Consultee Comments for Planning Application 21/00840/ADFULL

Application Number: 21/00840/ADFULL

Address: Ground Floor Lords Cricket Ground St John's Wood Road London NW8 8QN

Proposal: Details of details of the ventilation system to get rid of cooking smells pursuant to Condition 28 of planning permission dated 29 March 2019 (RN: 18/08510/FULL).

Sketch Title/Number:
Kitchen Extract Locations
LCAES-BHE-ZZ-ZZ-SK-MX-5005 (C01)

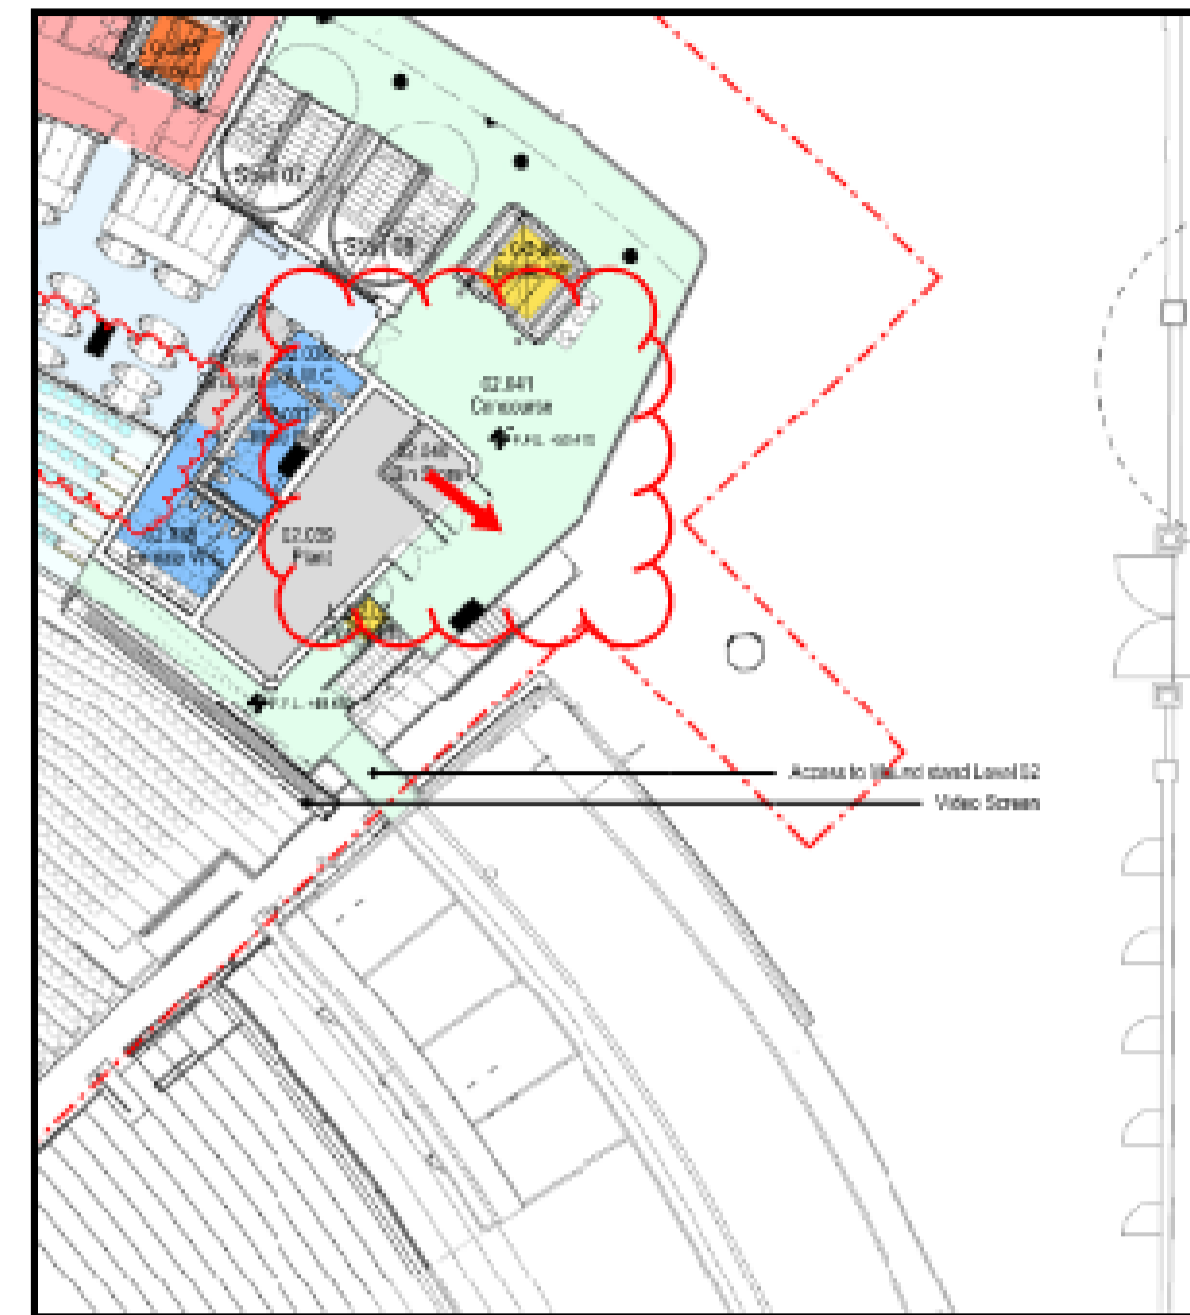
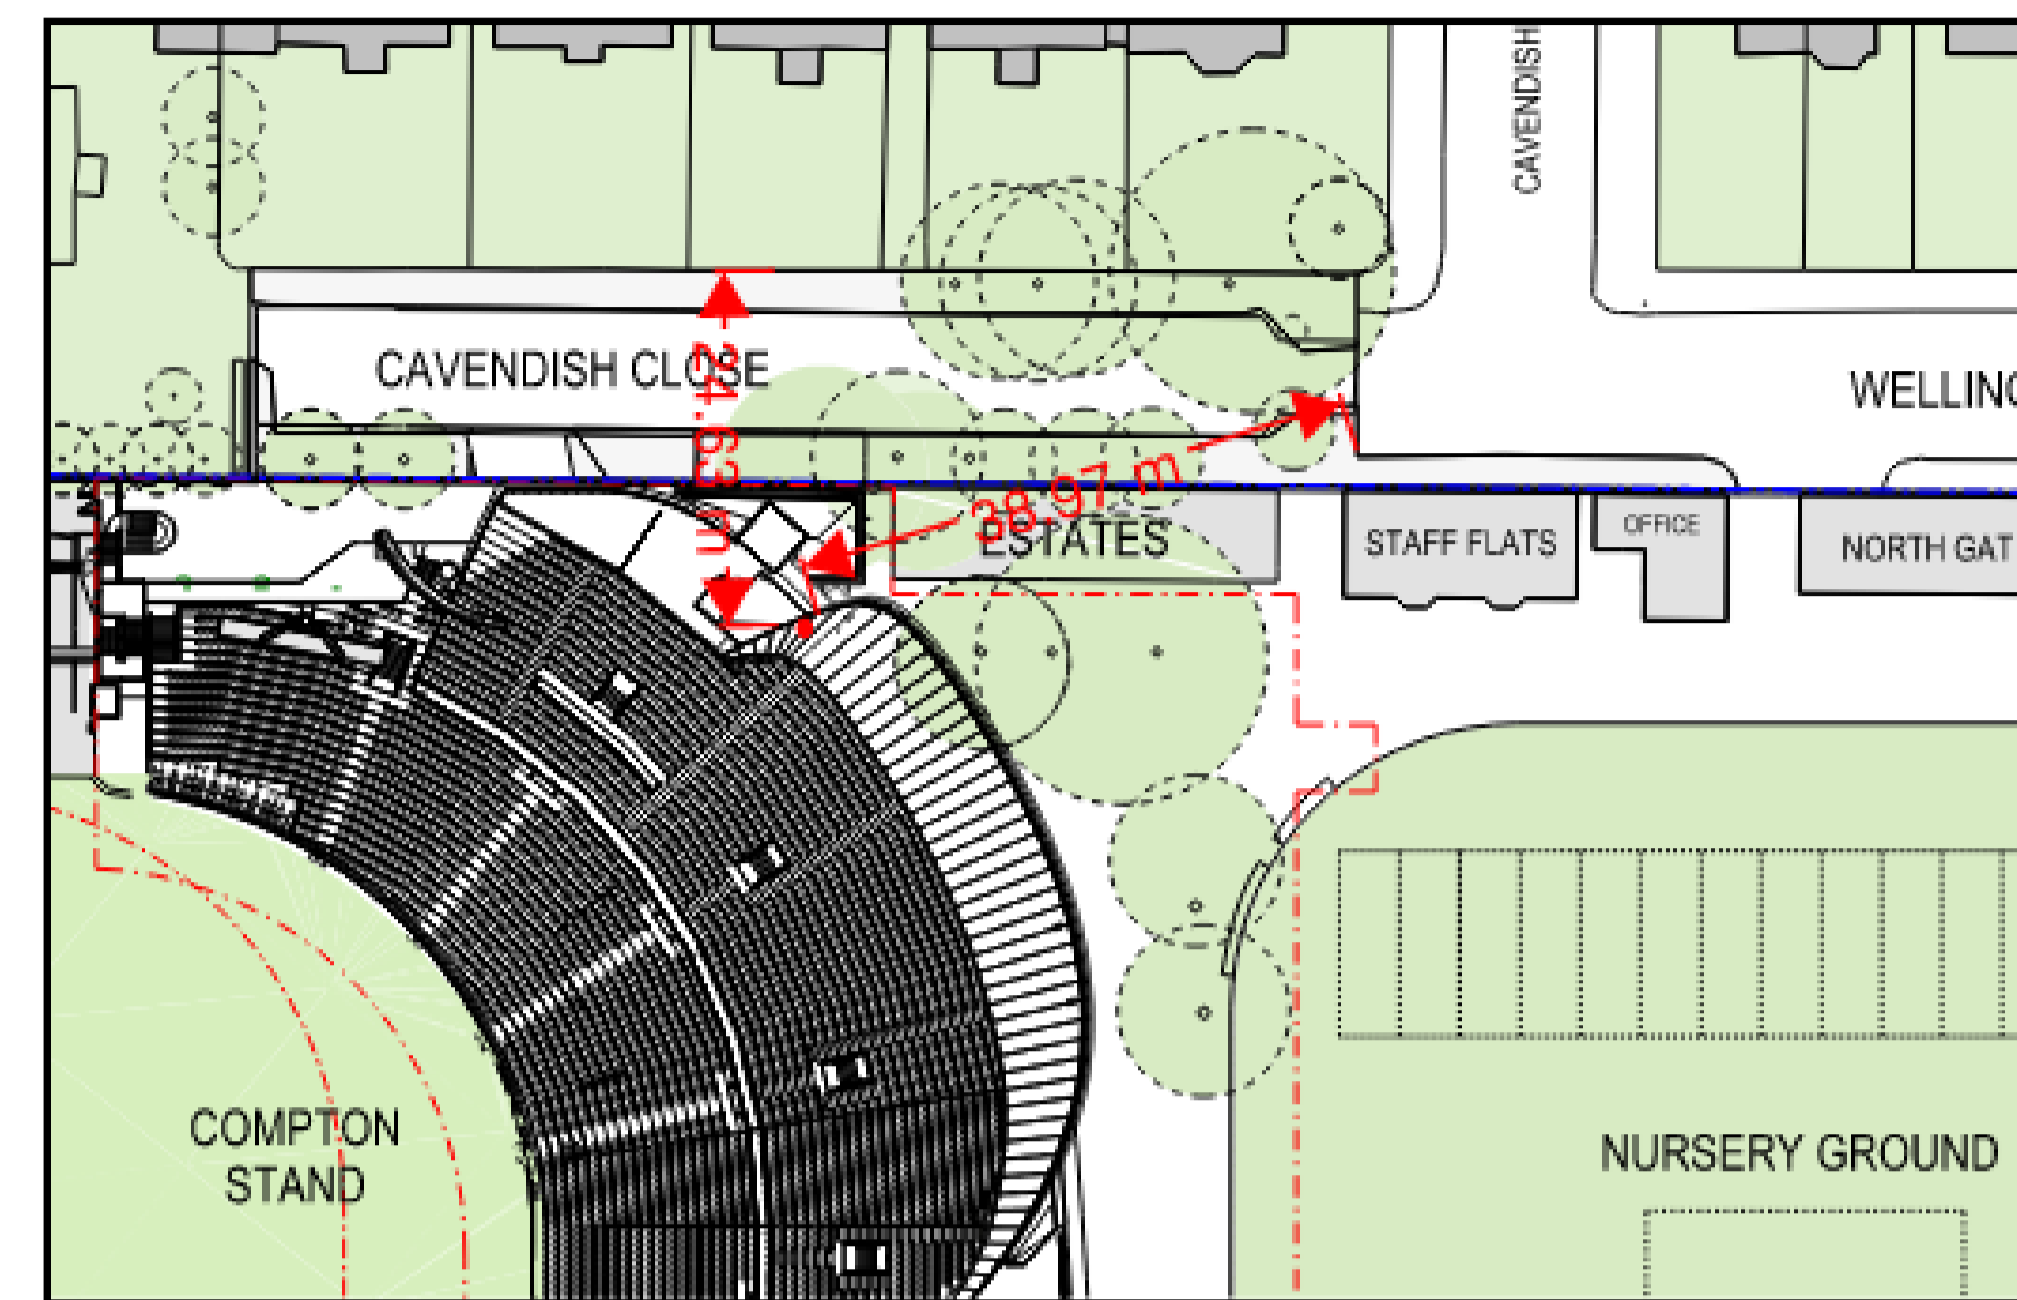
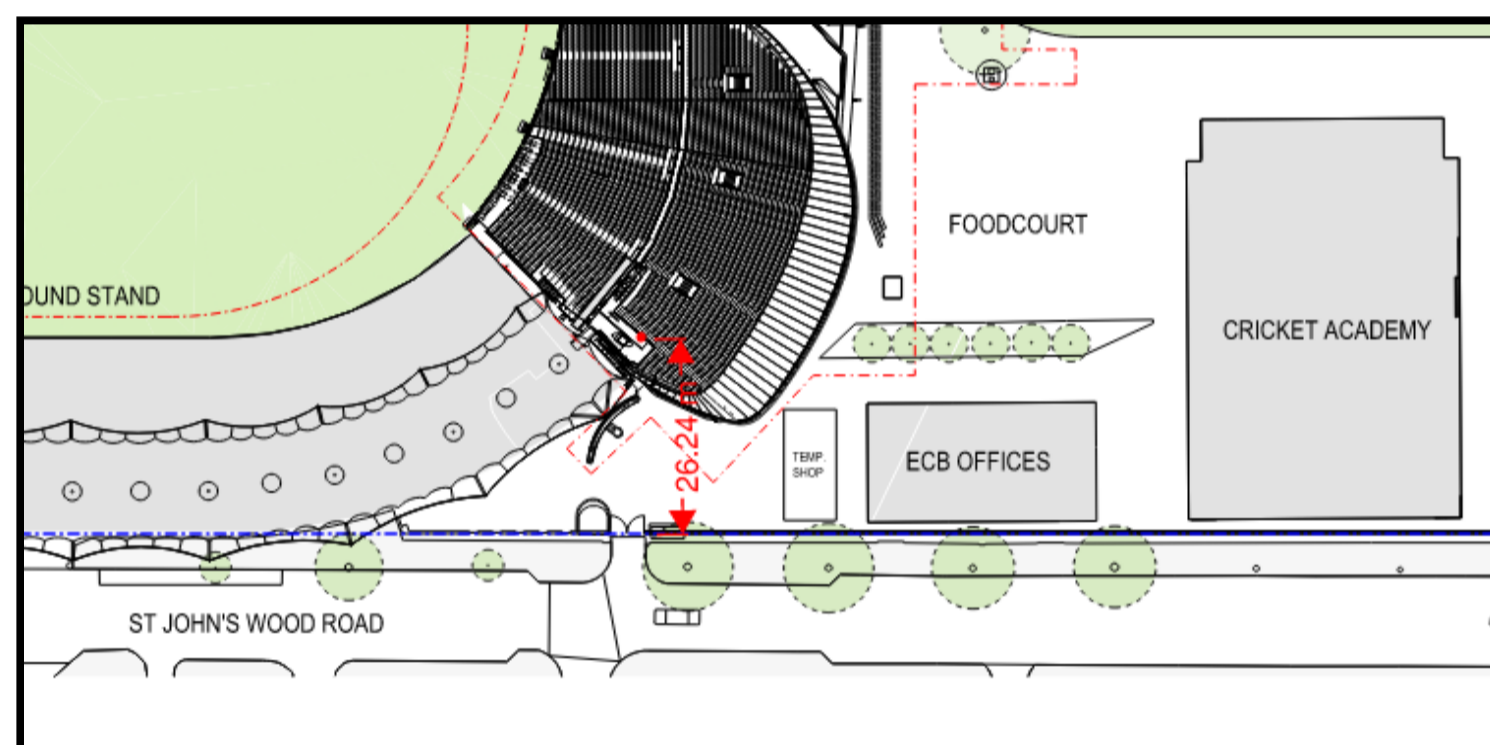
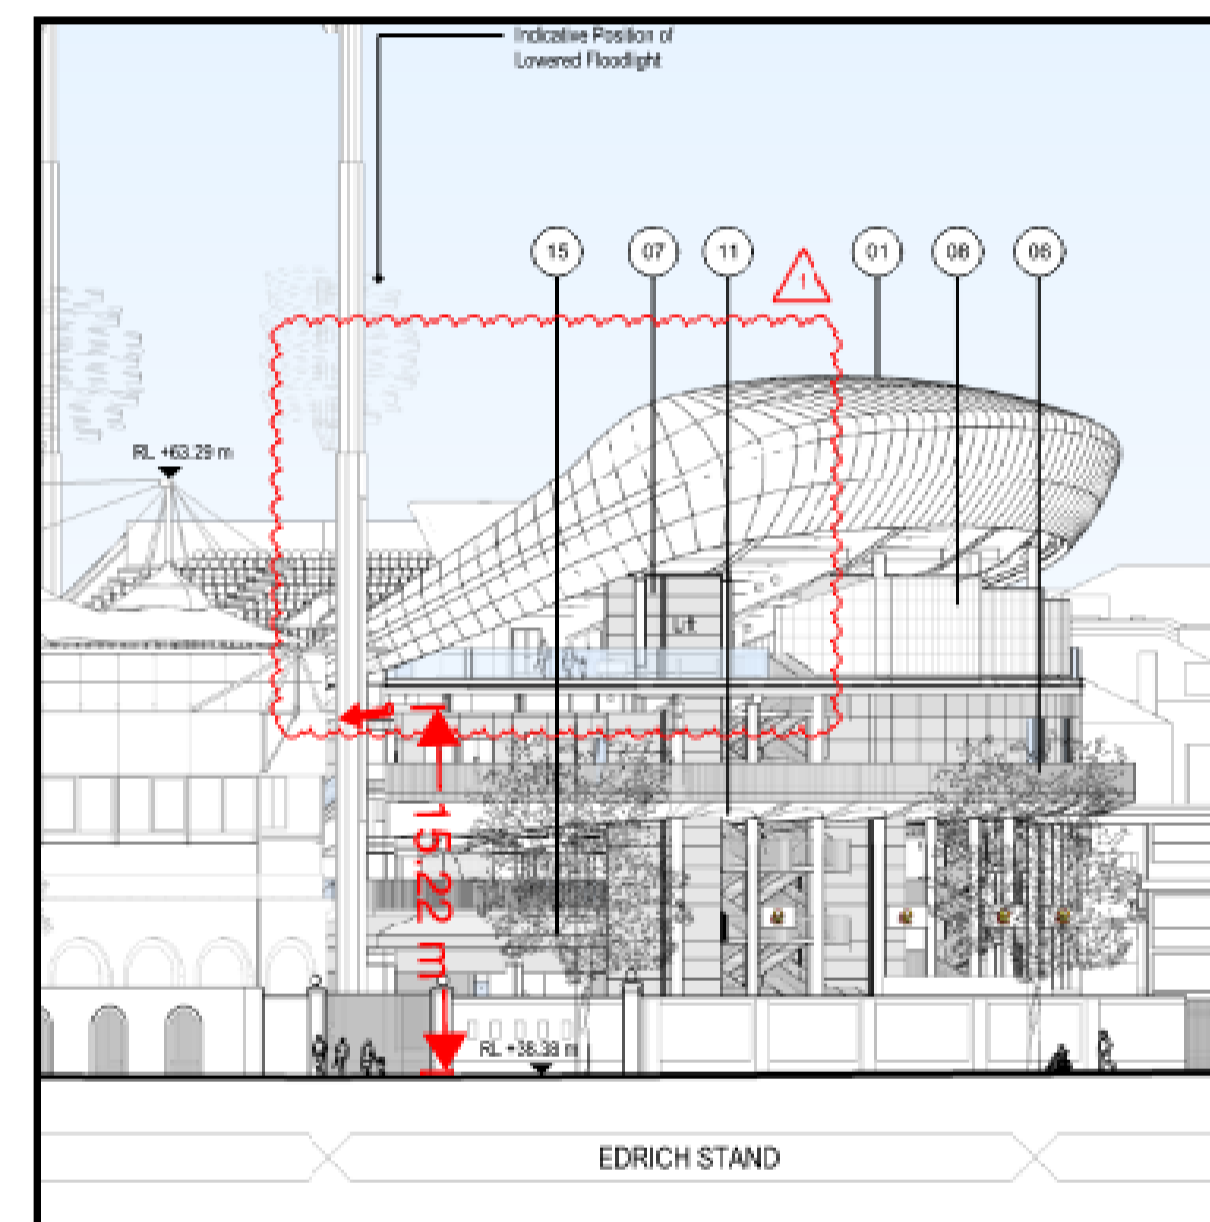
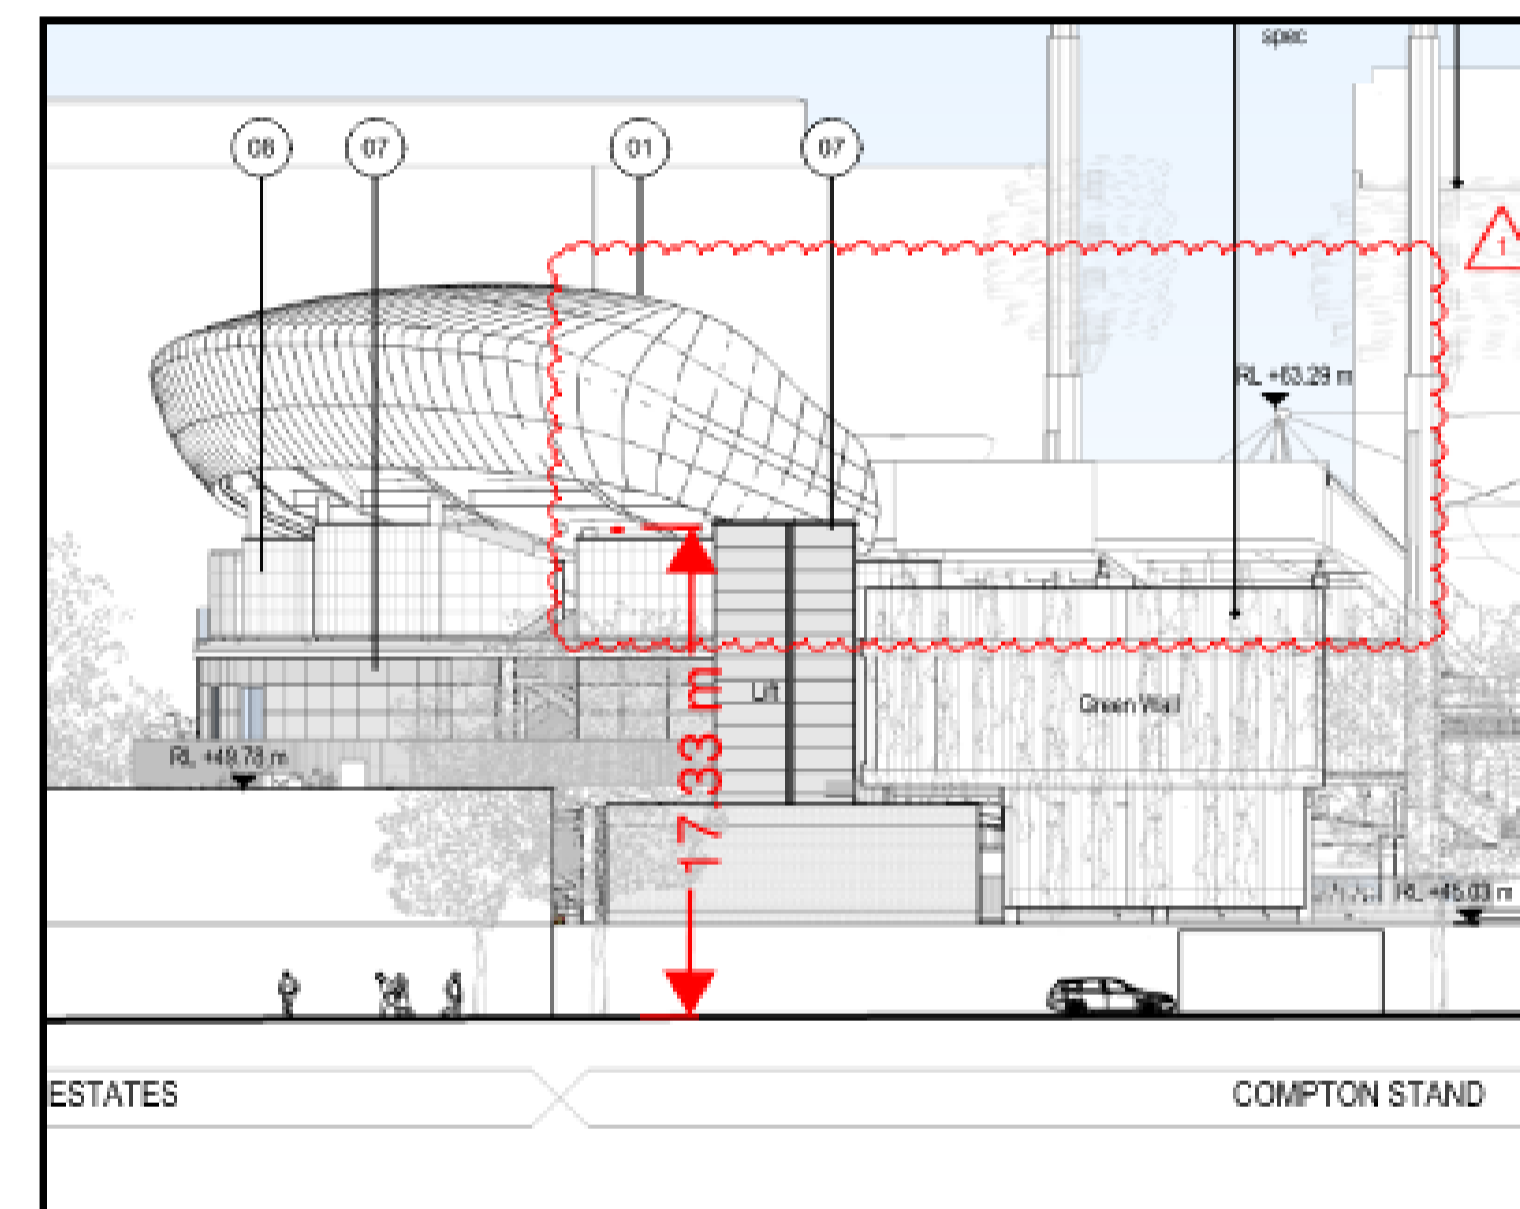
The application does not demonstrate where the kitchen extract terminates relative to the height of other buildings in the area; namely off site receptors. The application would have to meet the councils kitchen extract guidance. We require plans demonstrating the termination point of the kitchen extract, how that relates to receptors, including the distance and also the height of the termination point of the kitchen extract relative to receptors.
